January 10, 2022

Please add PCD
Project #
CDR-22-002

DRAINAGE LETTER – JUDGE ORR ROAD RV PARK & STORAGE

RANGE FLOWER WAY ROADWAY PLAN (PRIVATE)
URBAN NON-RESIDENTIAL COLLECTOR
SCALE = 1" = 60'

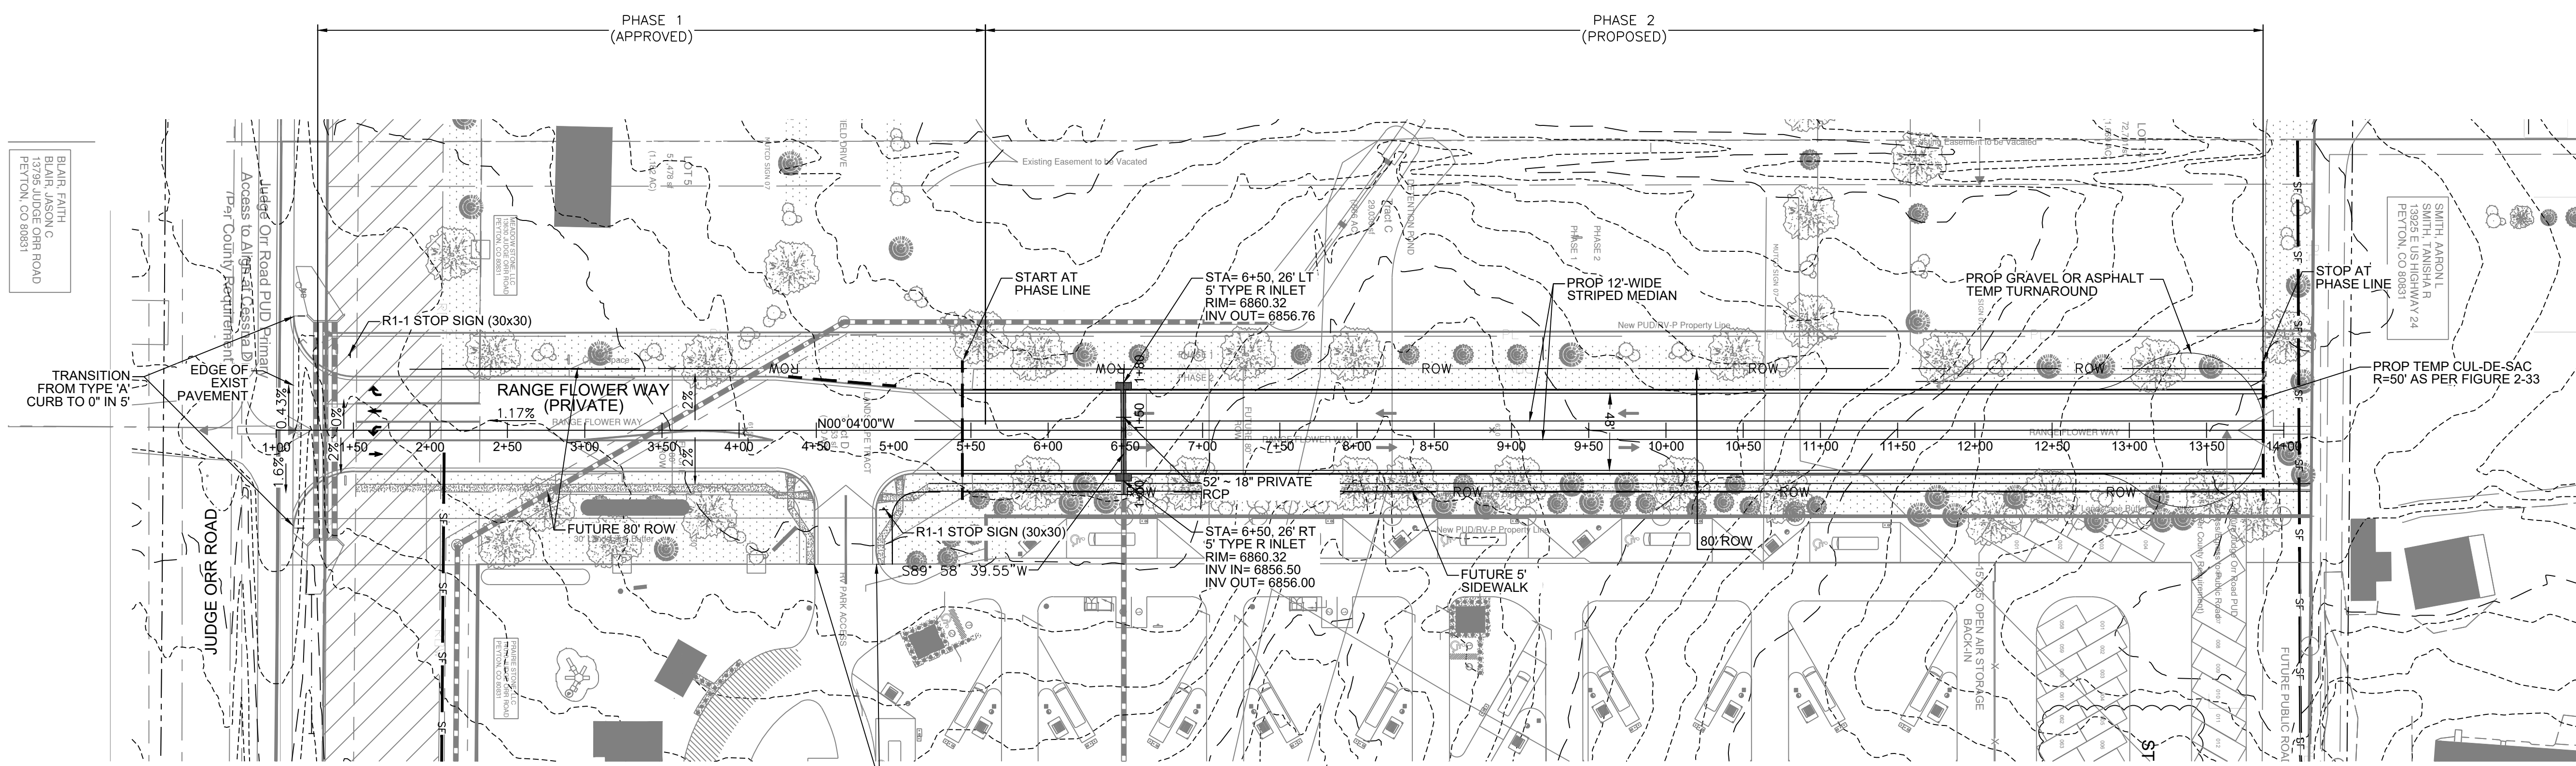
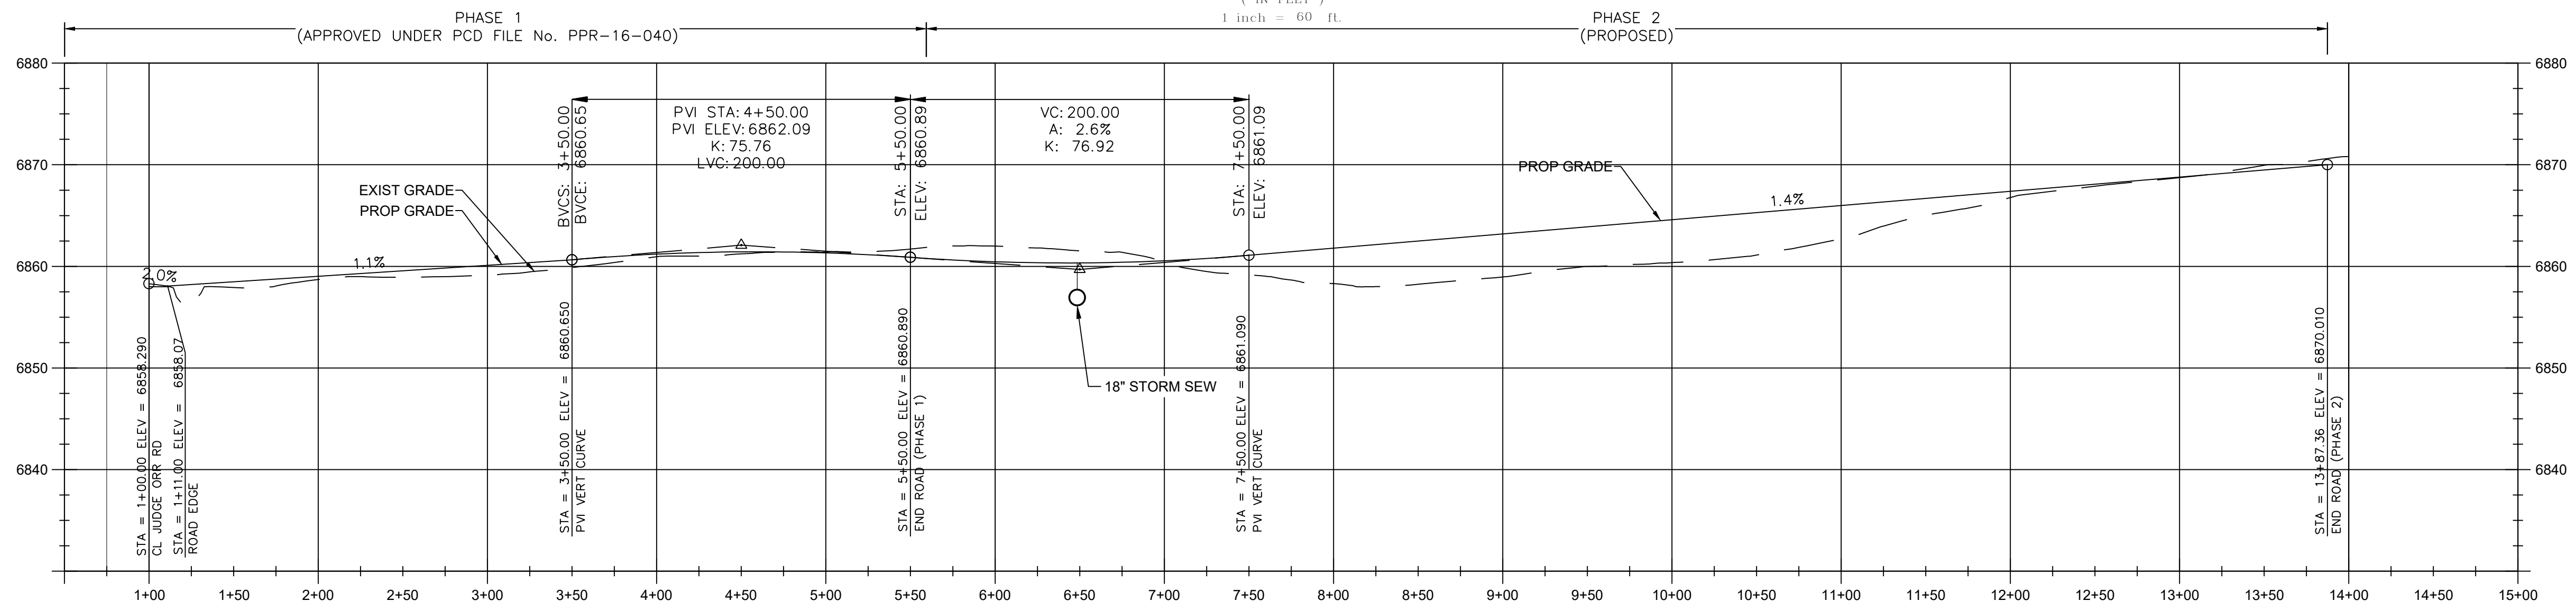
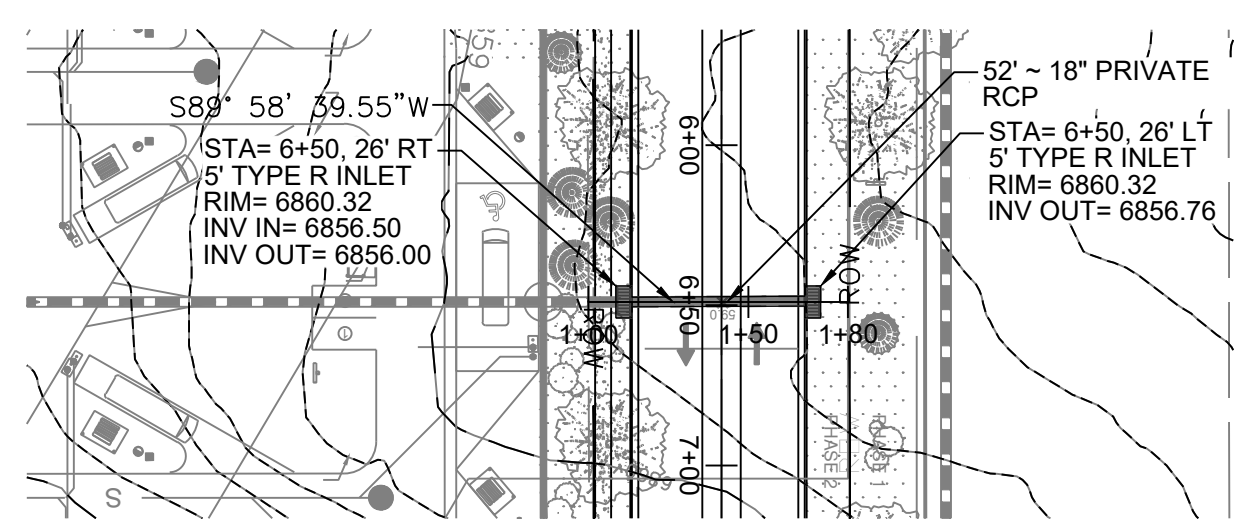
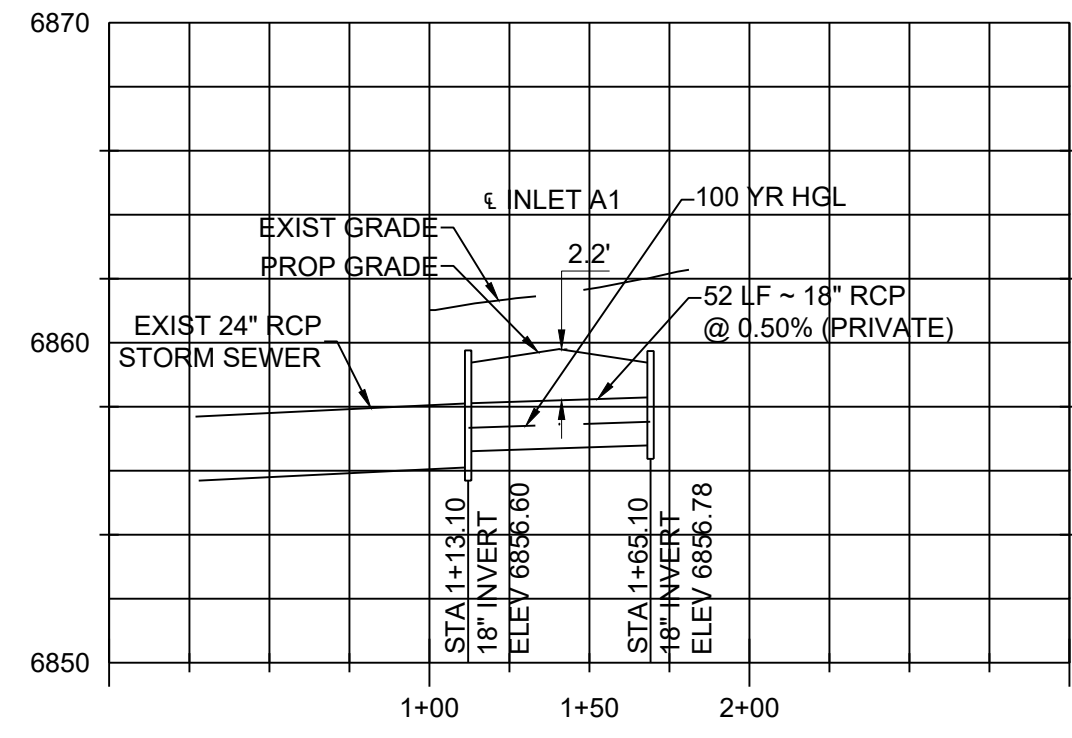
Submit inlet
calculations for the
two proposed inlets.
Revise to the
standard Type R inlet.
